FORESTS NSW

17 February 2013

RE: Woolgoolga to Ballina Pacific Highway Upgrade SSI-4963

I refer to your recent advice that comment was invited on Environmental Impact Statement prepared for the Woolgoolga to Ballina Pacific Highway Upgrade Project.

Figure 17-7: Iluka Road to Devils Pulpit upgrade – directly affected agricultural land

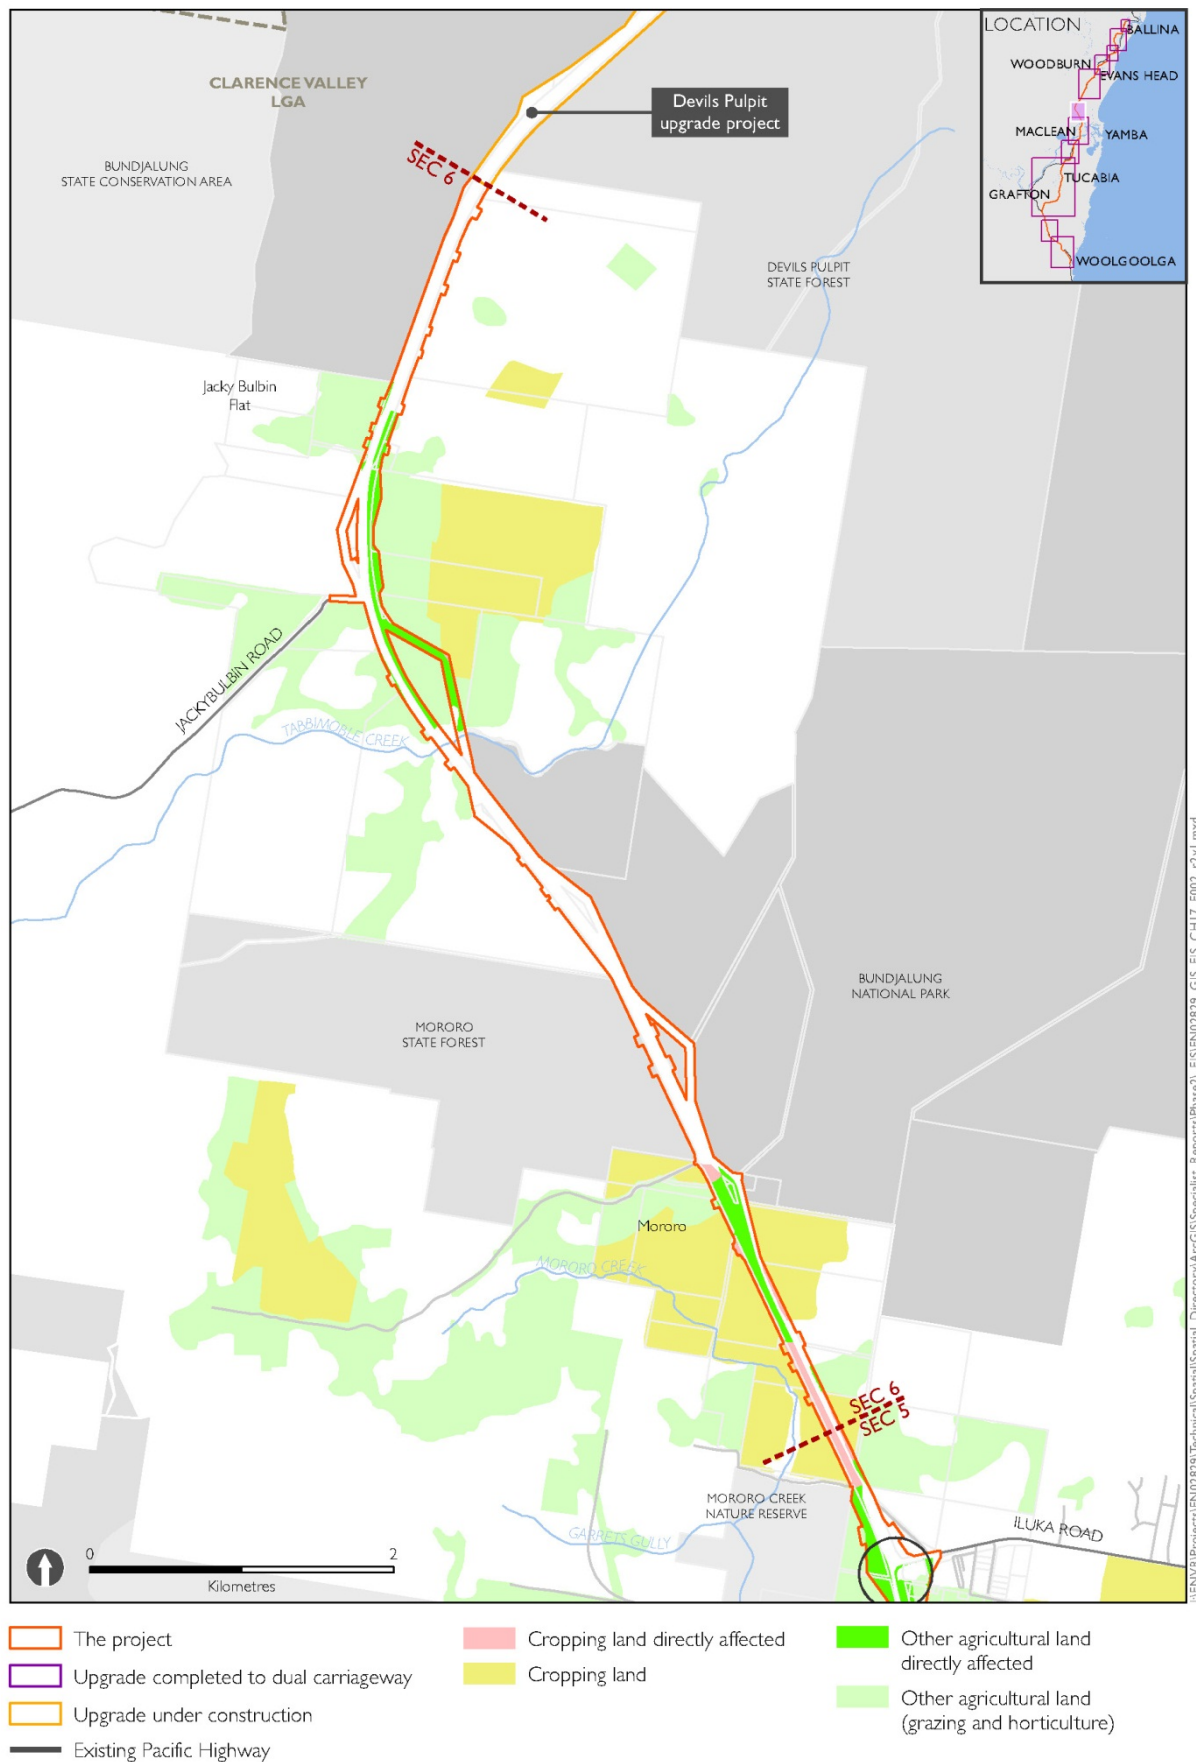
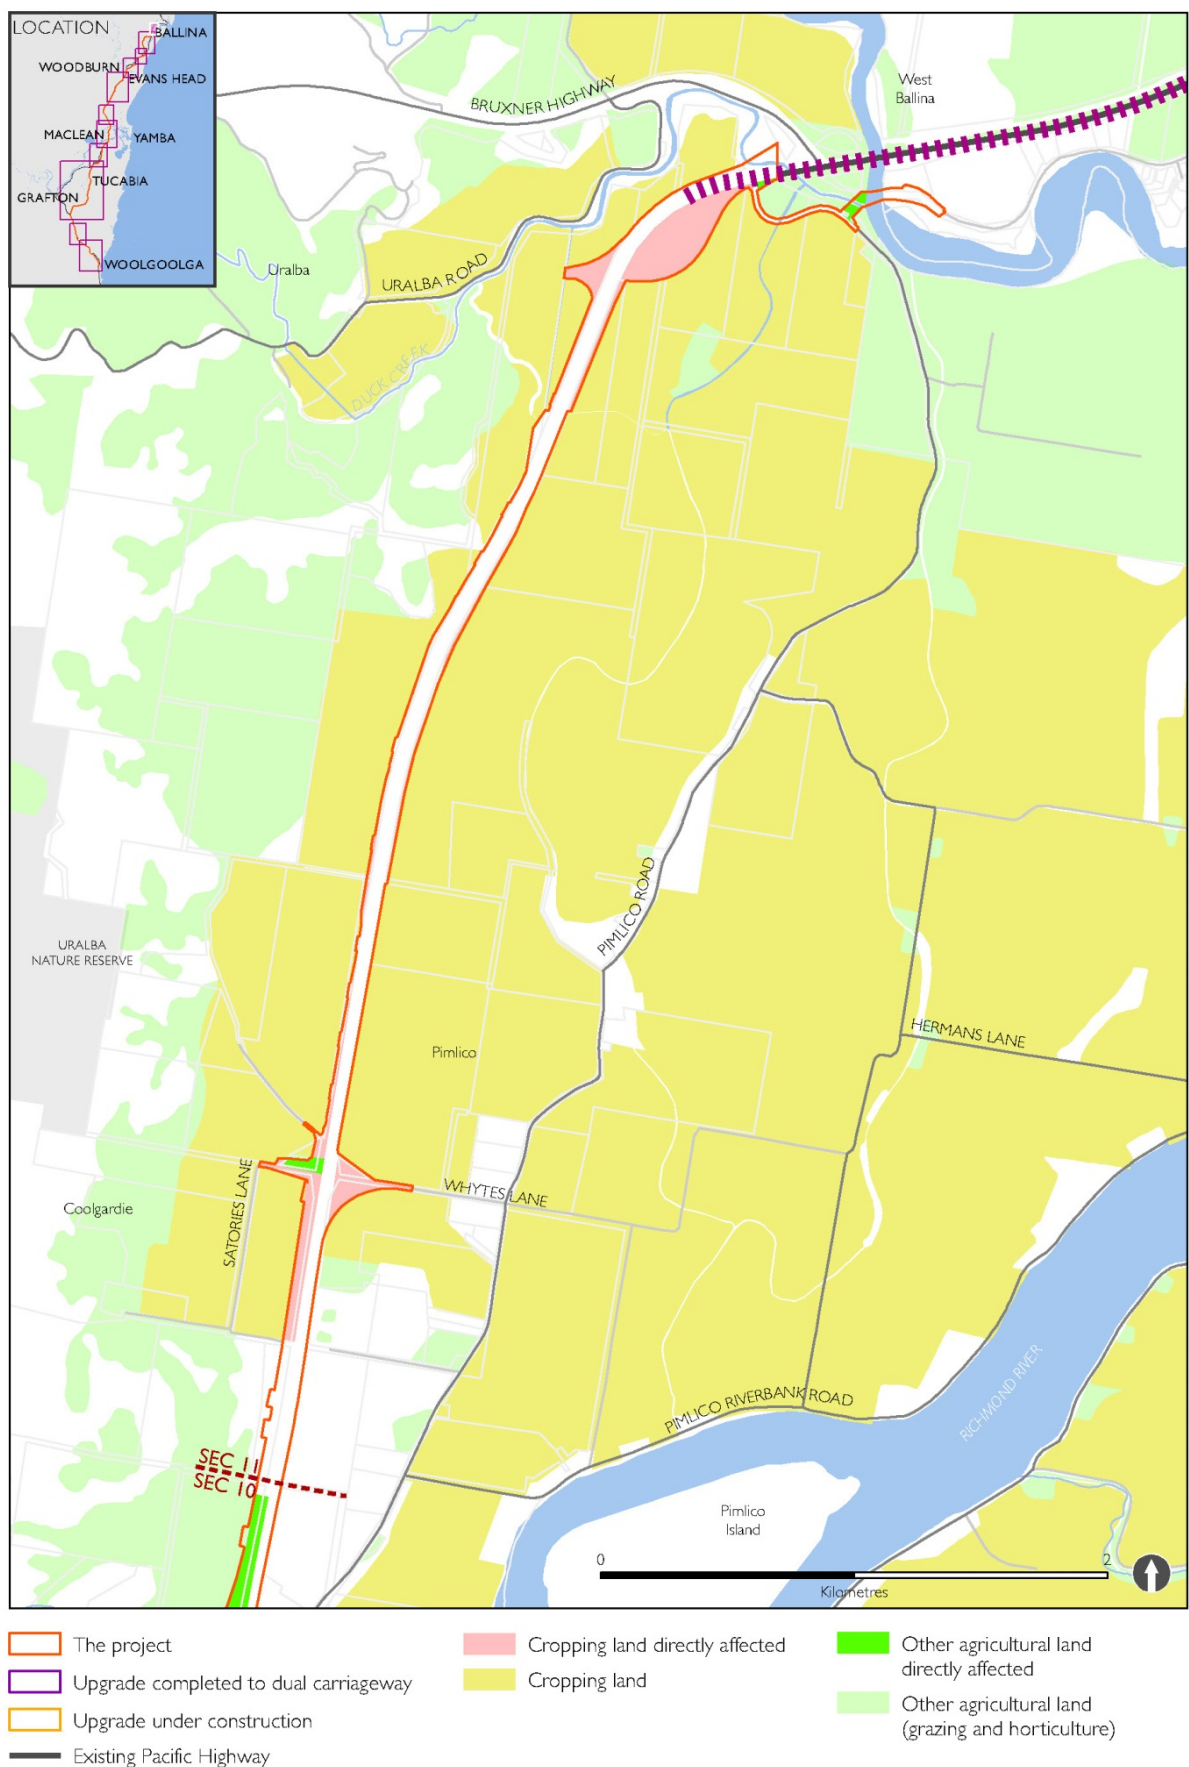
Tables 4.4 and 4.5 of the Social and Economic Working Paper and Table 17-2 in Section 17.3.4 (Agribusiness) of the Chapter provides an estimate of area of "hardwood production" within the Local Government areas affected by the project as well as an estimate of the area affected directly by the project. The areas cited may be limited to areas of hardwood plantation only and the impact on the area of native forest used for hardwood production has not been considered.
